From: Elizabeth Lawrence [REDACTED]
Sent: 03 September 2017 09:03
To: Anita Gardner
Subject: Fw: Kents Yard

CM/19/17/PL

From: Chris McDermott
Sent: 01 September 2017 15:57
To: 'Liz Harris'
Cc: 'Matt Hore'; 'Tony Smith'
Subject: Kents Yard

Further to our recent call, attached are the updated elevations and the associated floor plan.

drawing
proposed
elevations 1 of 5

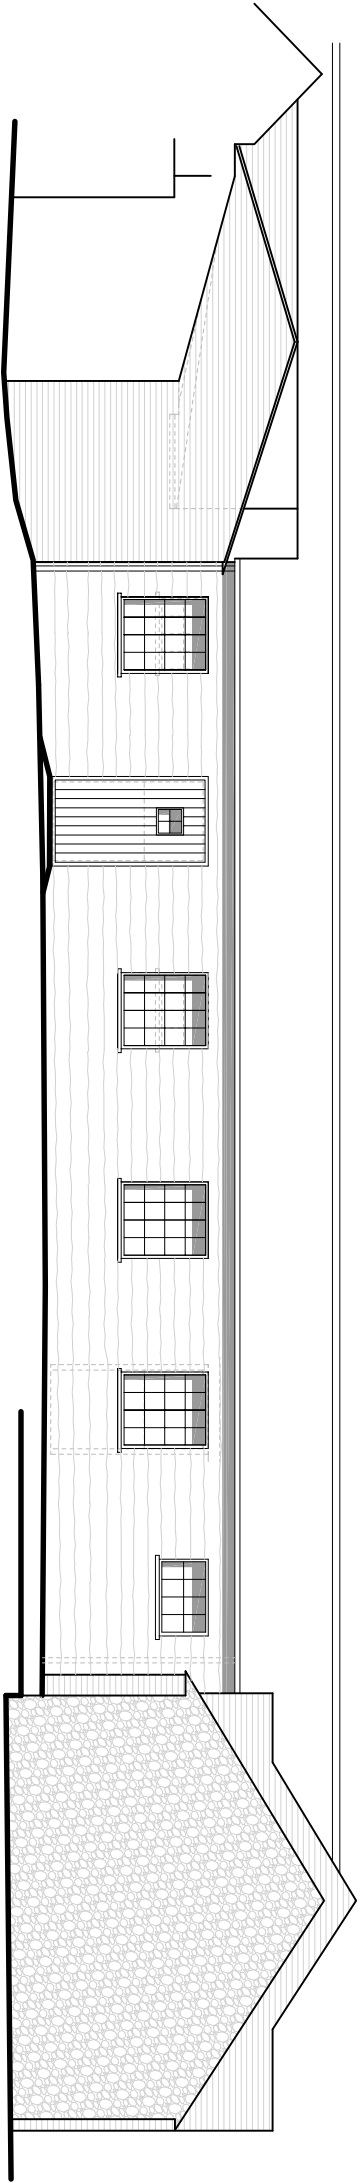
- proposed windows largely remain as the existing openings.
- any timber cladding returned to brickwork.
- elevation sheet 4 - windows changed to more linear/casement form as desired.
